**Consultation Response from KC, Highways Development Management**

**2021/91506 Shop Lane, Kirkheaton, Huddersfield, HD5 0DB**

**Reserved matters application pursuant to outline permission 2014/92535 for erection of 48 dwellings, formation of access and associated infrastructure**

**Date Responded: 11/06/21**

**SHOP LANE**

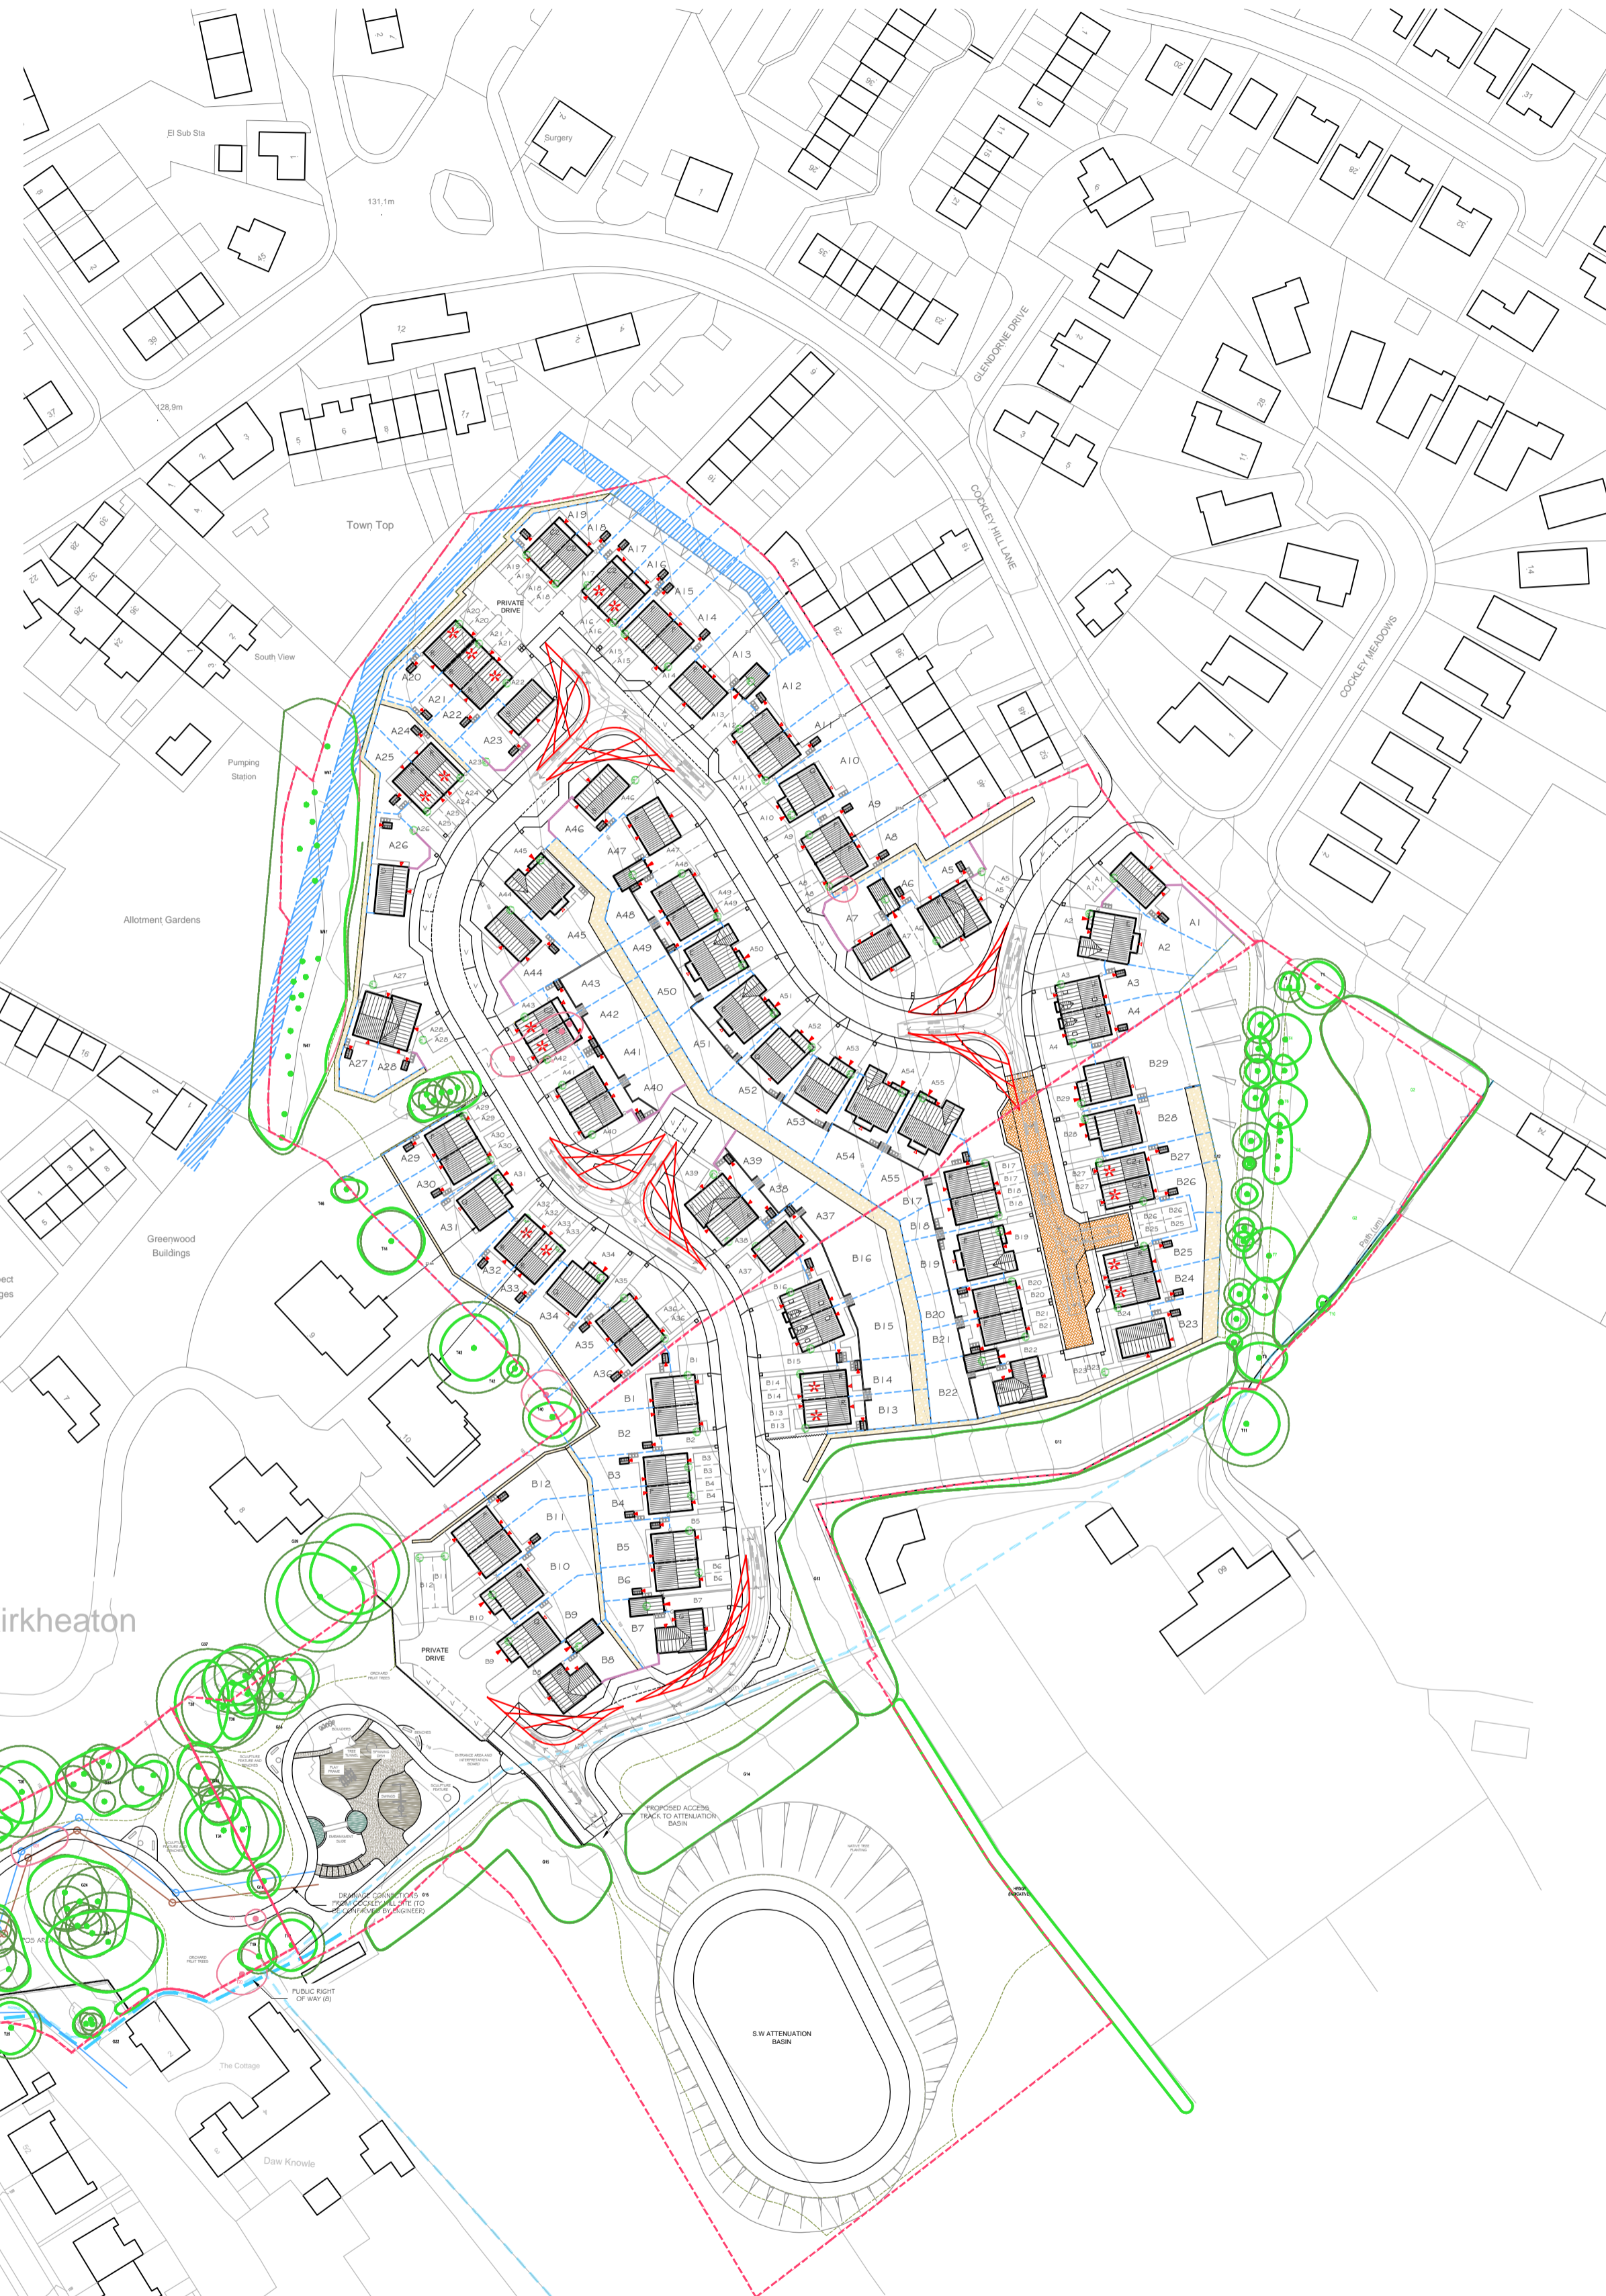
- Resident parking should be in line with the recommendations made in Kirklees' Highway Design Guide SPD, and where it isn't, justification should be made using local car ownership and/or TRICs data.

- Visitor parking to be improved throughout the site. This should be demonstrated at a rate of one space per four dwellings.
- Swept path analysis of an 11.85m refuse vehicle accessing and exiting the site in a forward gear demonstrated on a plan. This should be both for the phase one and full layouts.

- Details of bin storage and collection pads should be demonstrated on a plan. The refuse vehicle should not enter the un-adopted highway, so communal pads would be required for those dwellings served off a private drive. Maximum dragging distances can be found in the Highway Design Guide.

- Indicative long section along the centre line of the proposed road to determine gradients should be demonstrated on a plan along with carriageway widths and forward visibility on bends.
